RE: Sevilla @ Andalusia - (File: F11D015C)
Drainage Management Plan, Engineer's Stamp Date 12-19-2014
Grading and Drainage Plans, Engineer's Stamp Date 12-18-2014

Based upon the information provided in your submittals received 12-19-14, the above referenced submittals cannot be approved Preliminary Plat and Site Plan for Subdivision action by the DRB until the following comments are addressed.

**STORM DRAIN PLAN AND PROFILE**

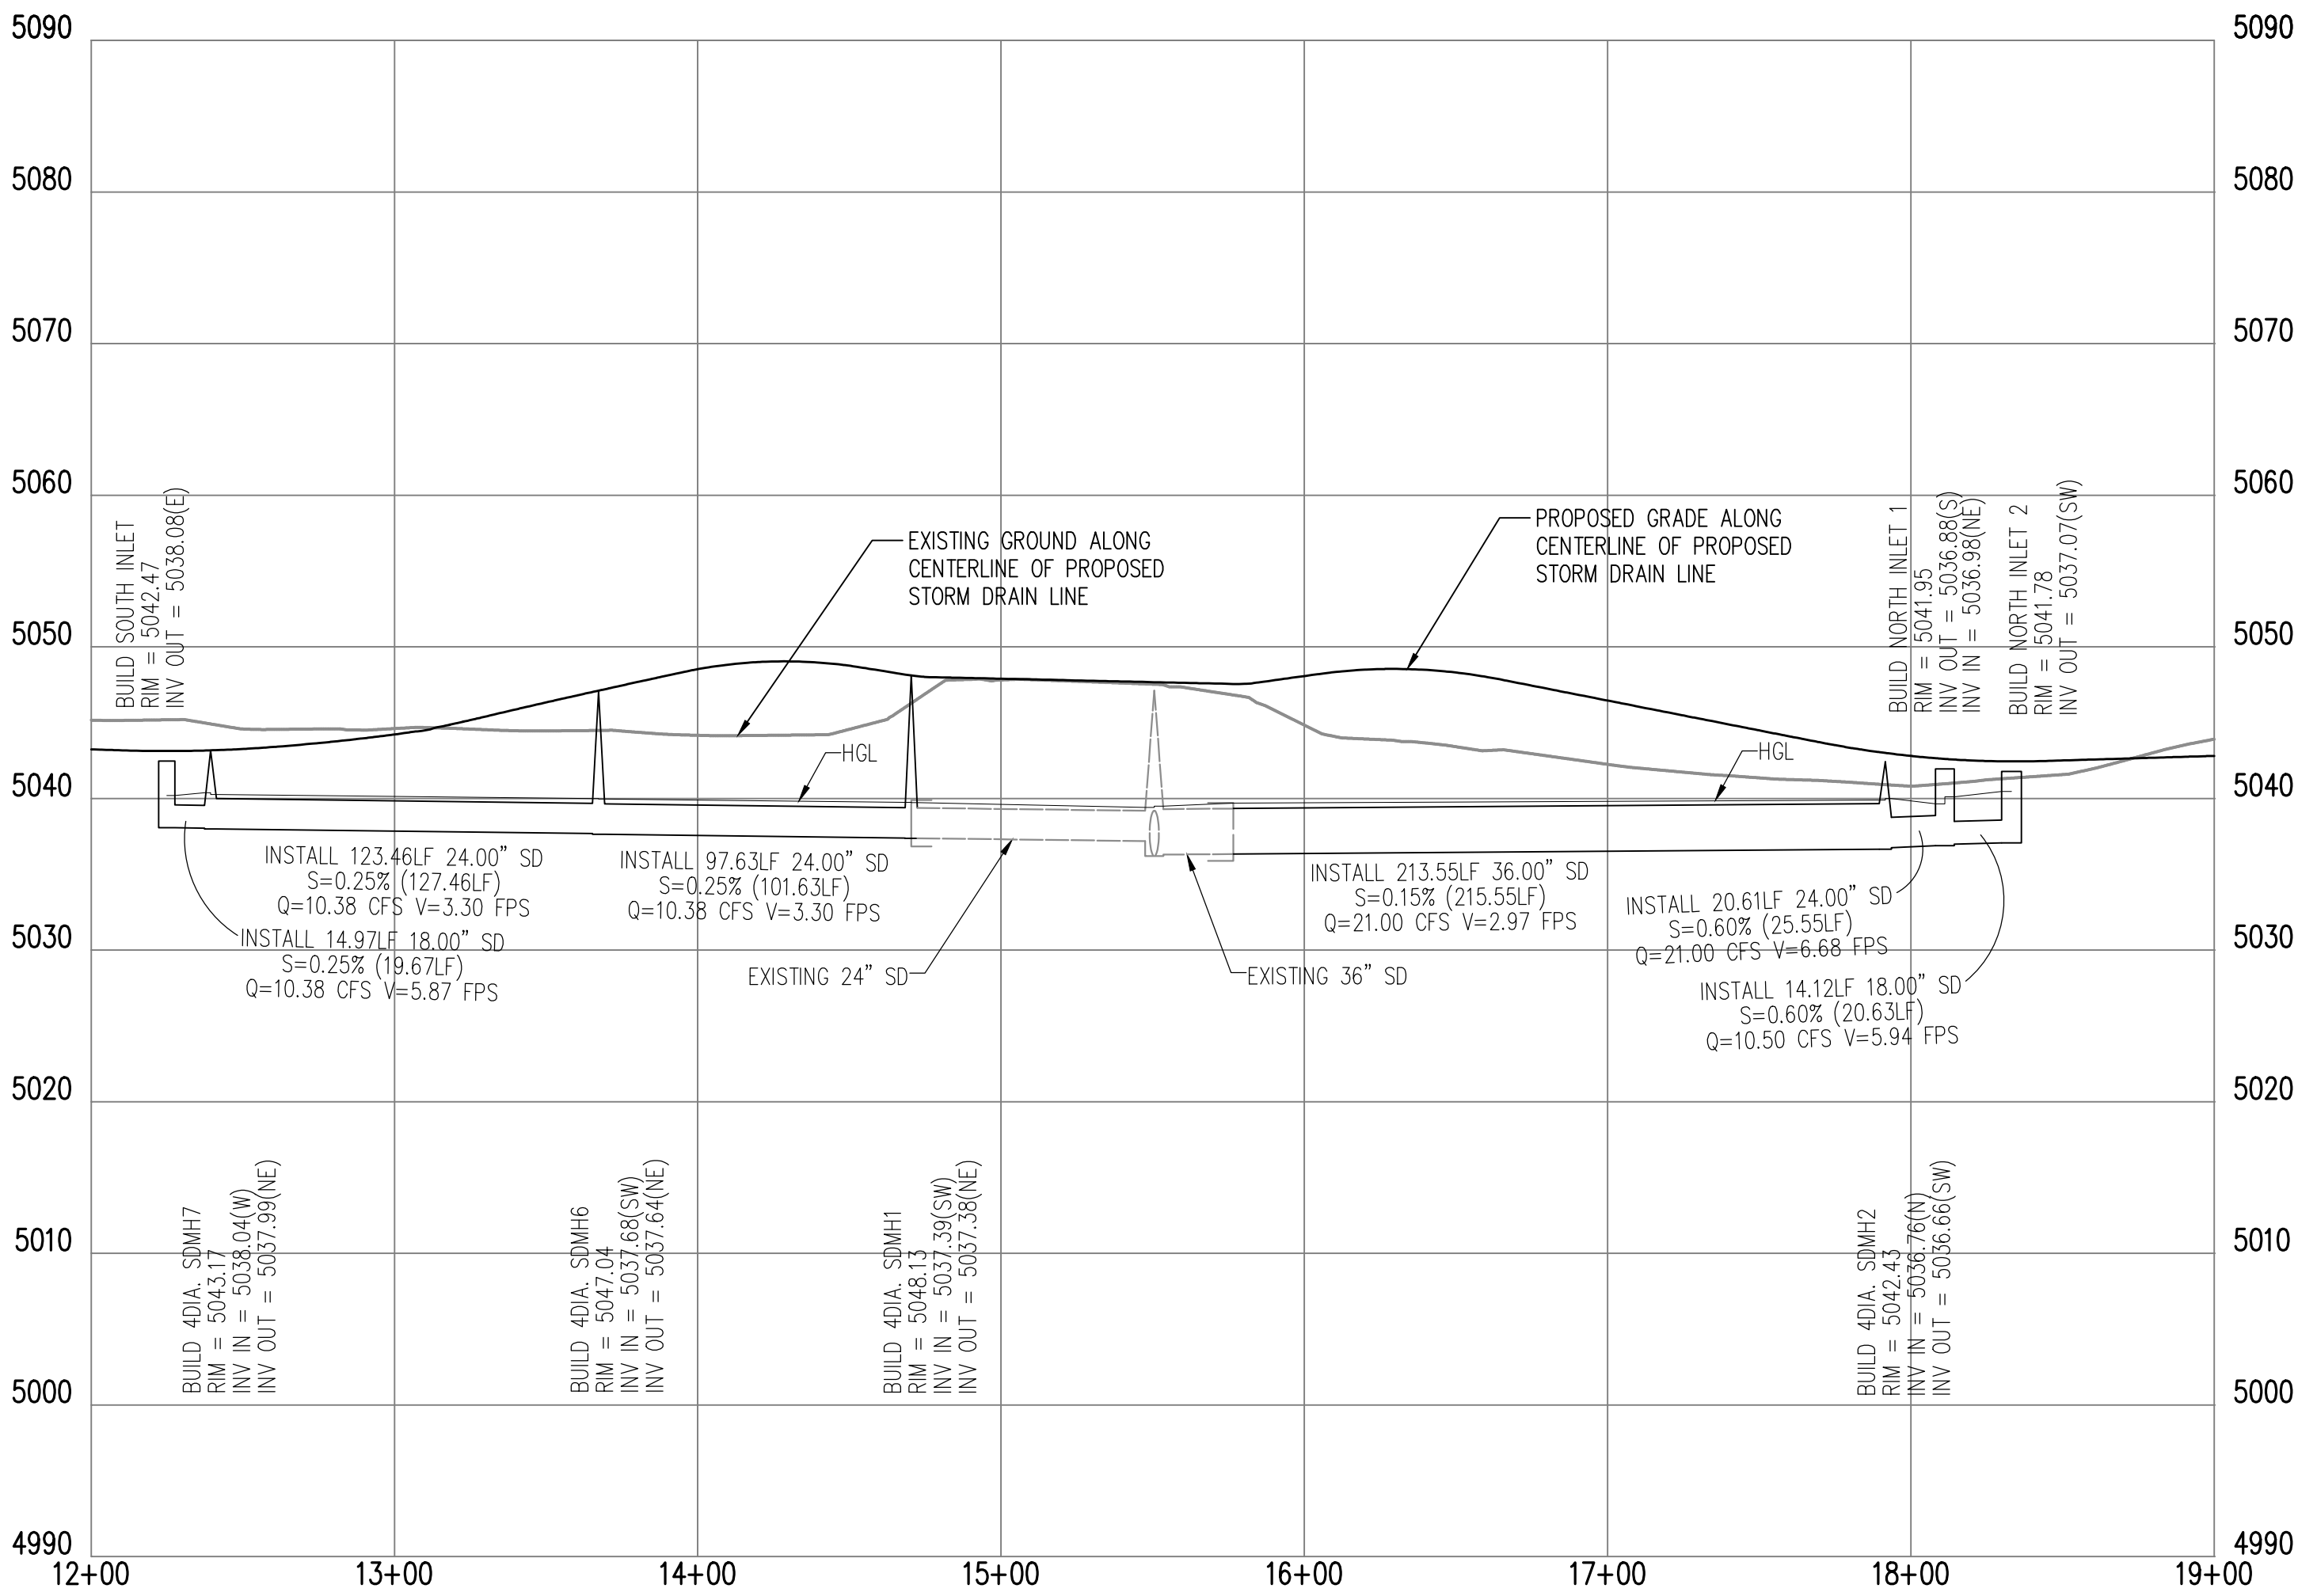
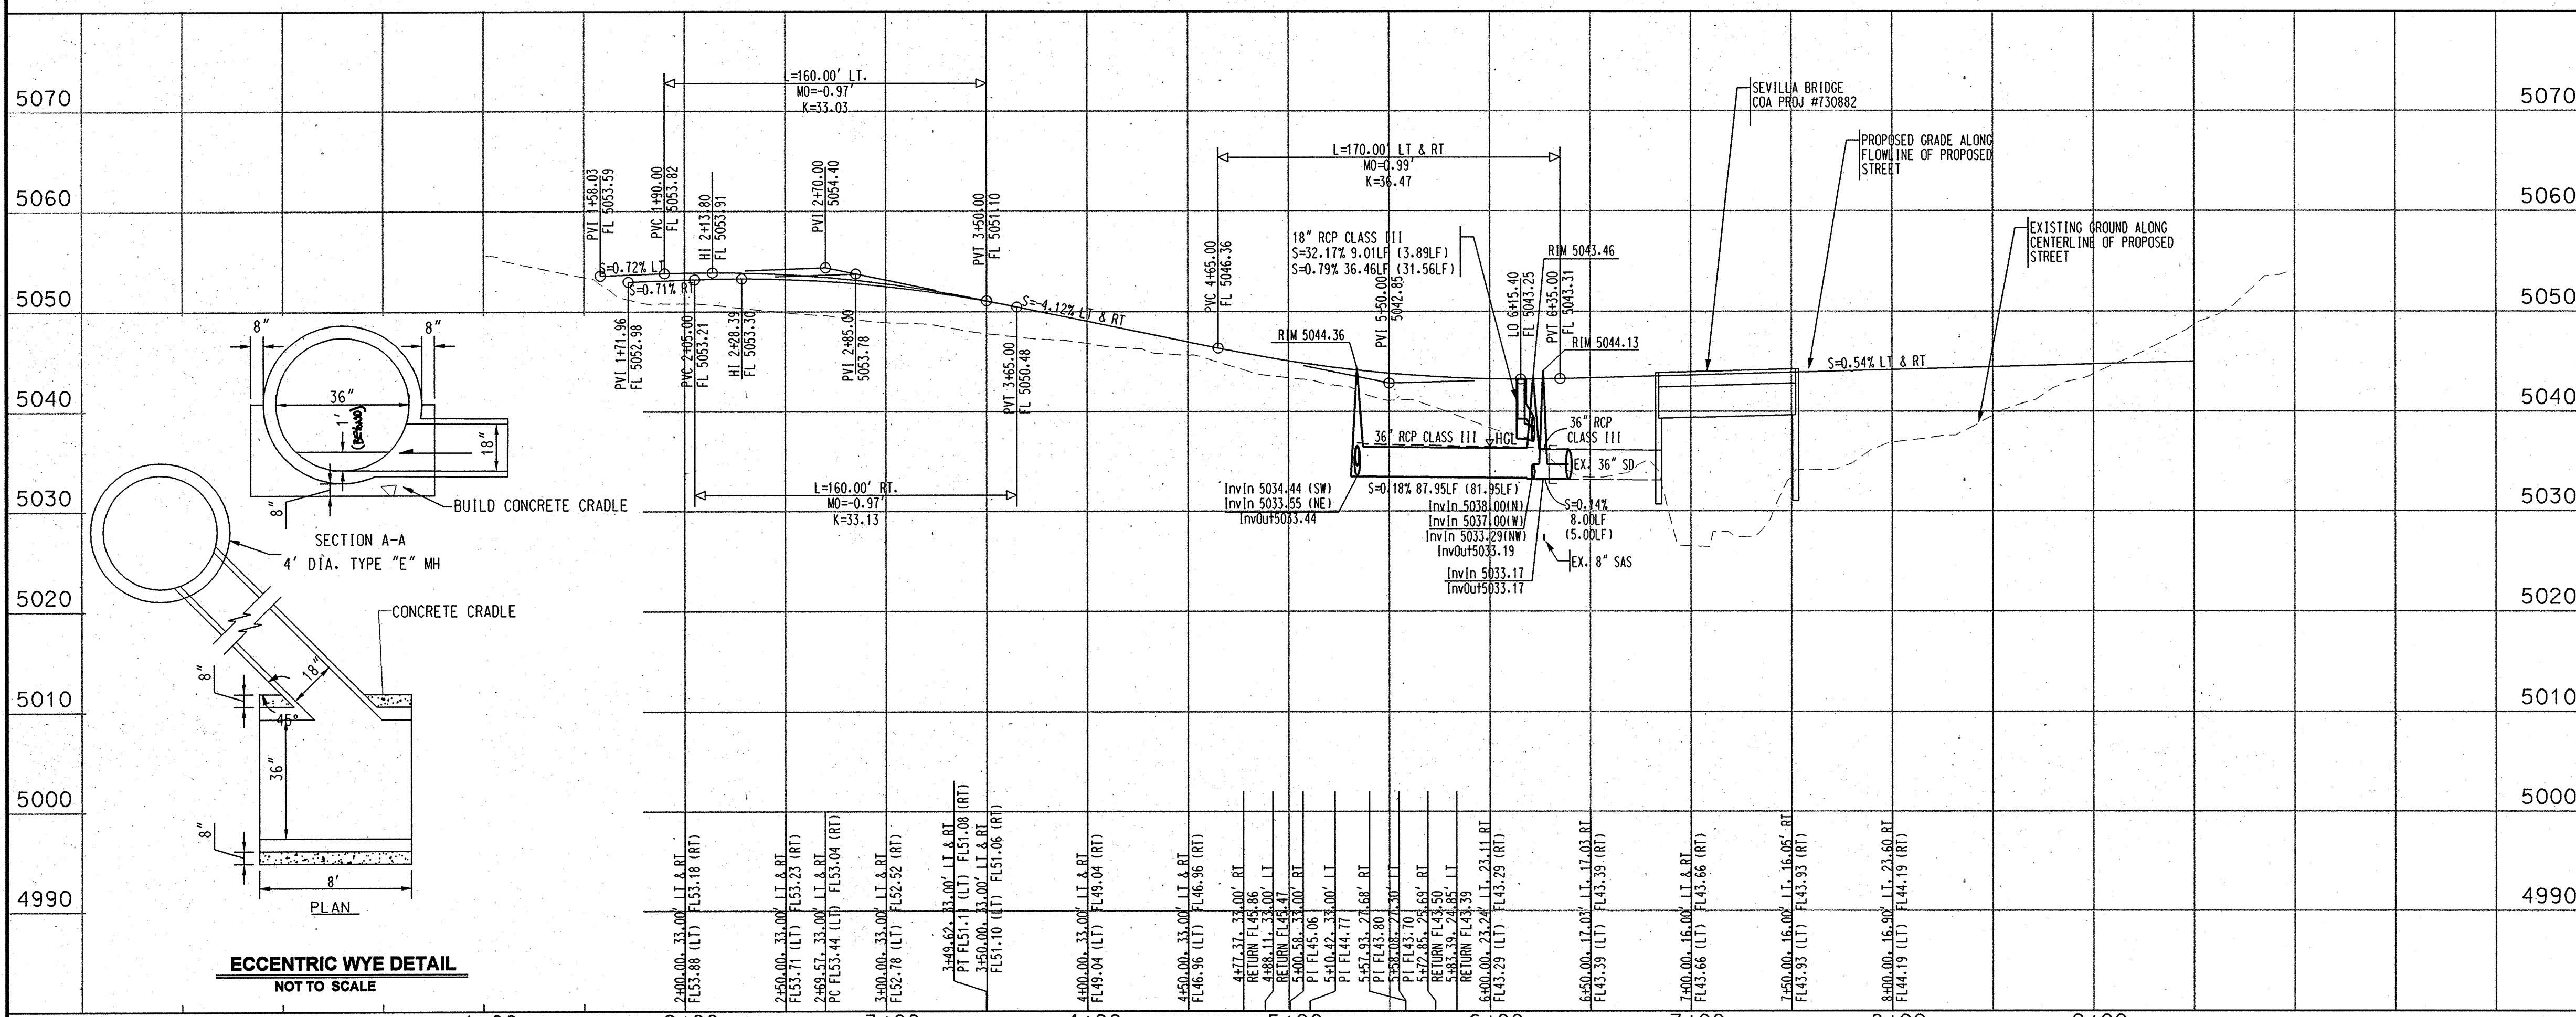
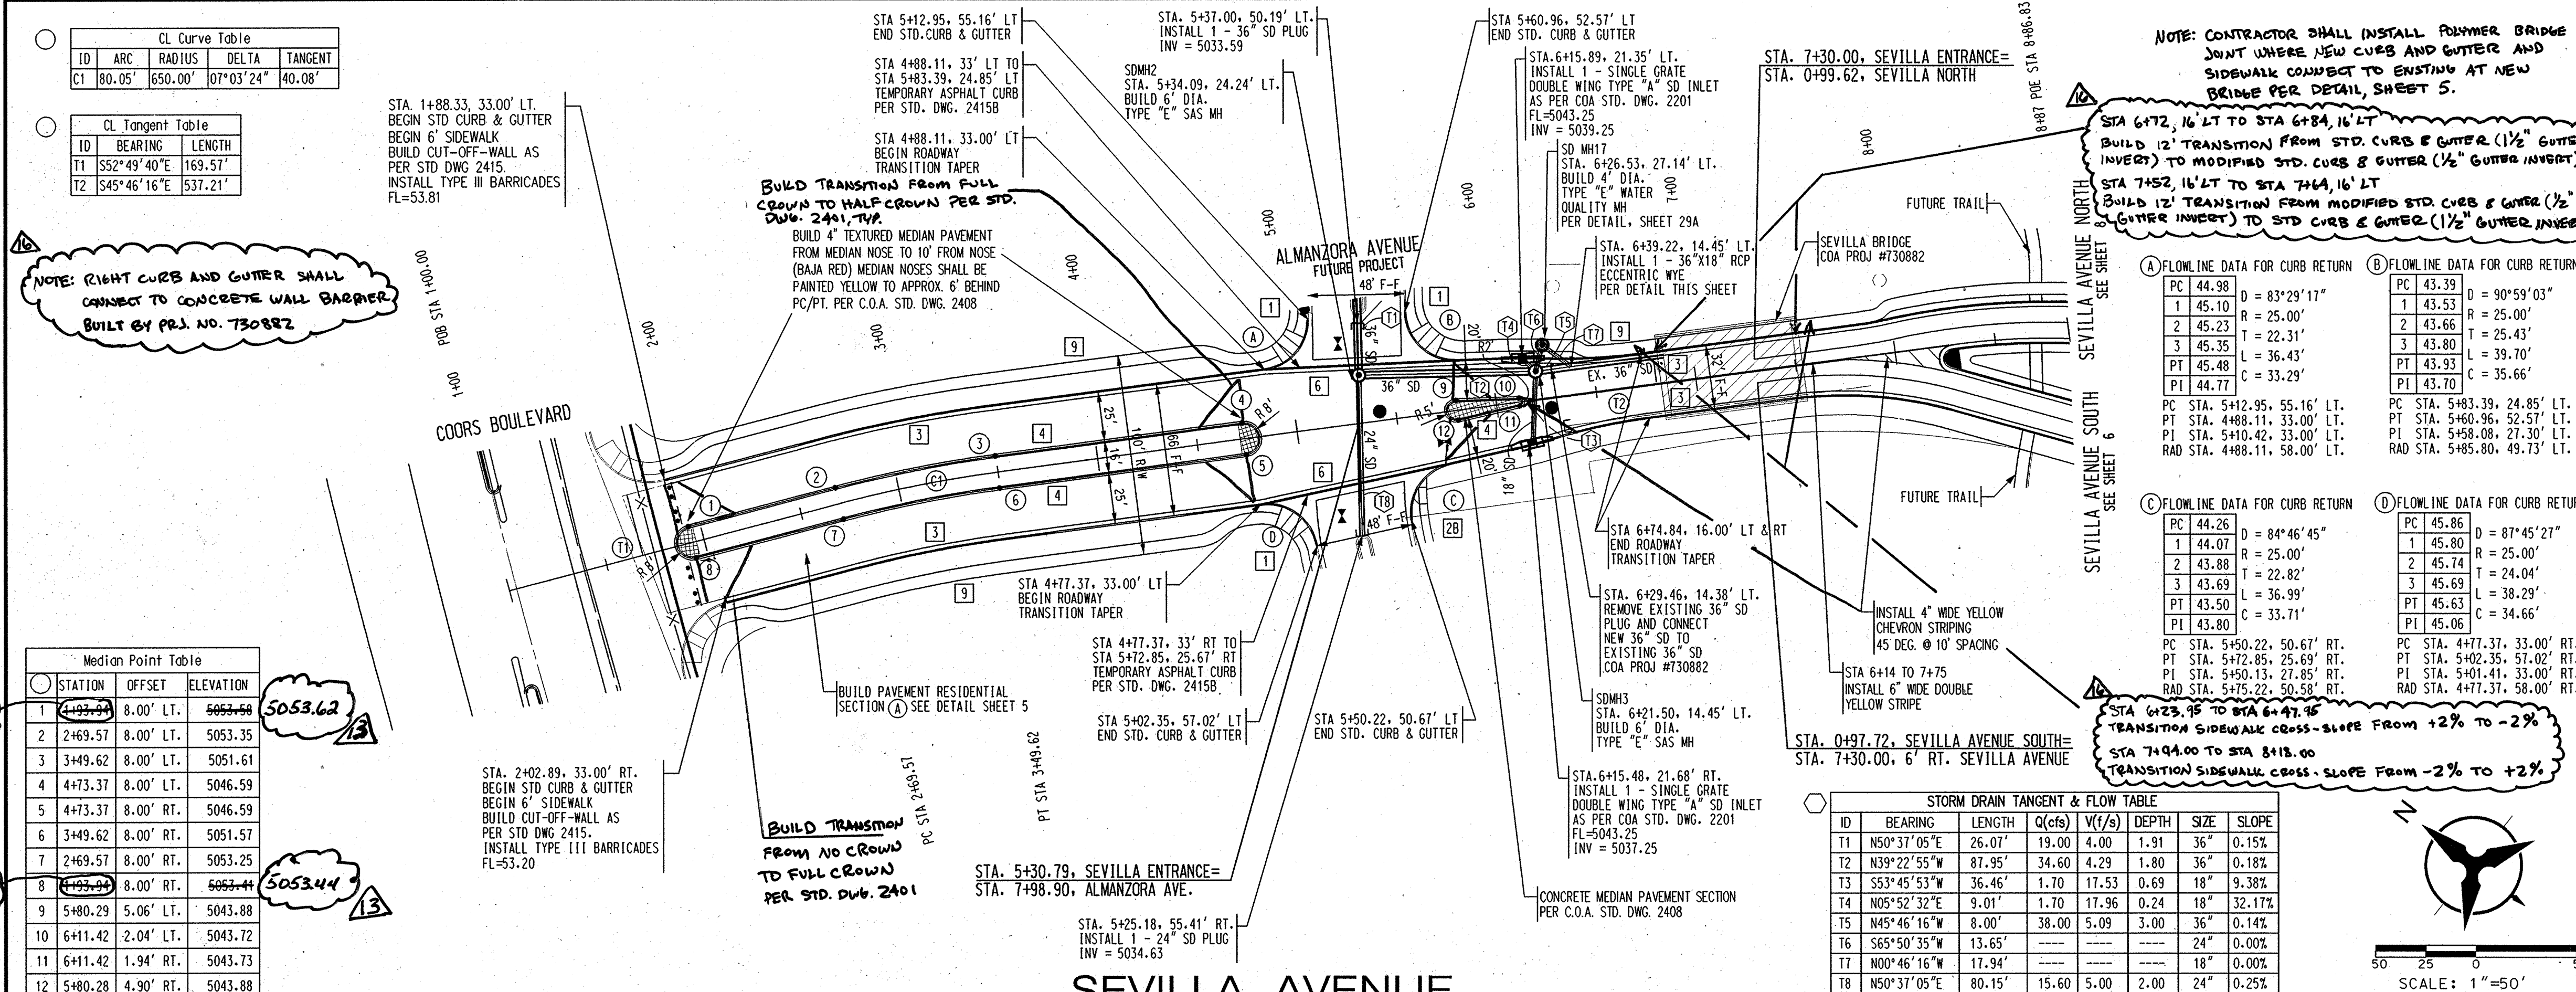
23. Indicate on the Grading plan where standard curb and mountable curb will be used.
24. Sump in north side (Tract B-2) shows 2 inlets on the Storm Drain Network map, but only 1 inlet on the Grading Plan. The report states that a double grate inlet will be used, but is not indicted elsewhere. Further, the Calculations state that the required capacity is 26.8 cfs, but the Allowable Capacity is for one inlet is 14.5 cfs. Similar comment is for the sump inlet in the south side (Tract A-1-A).

26. For the storm drain analysis, provide a graphic representation showing the storm drain, the grade, the HGL and the pipe ID's used in the InRoads program.
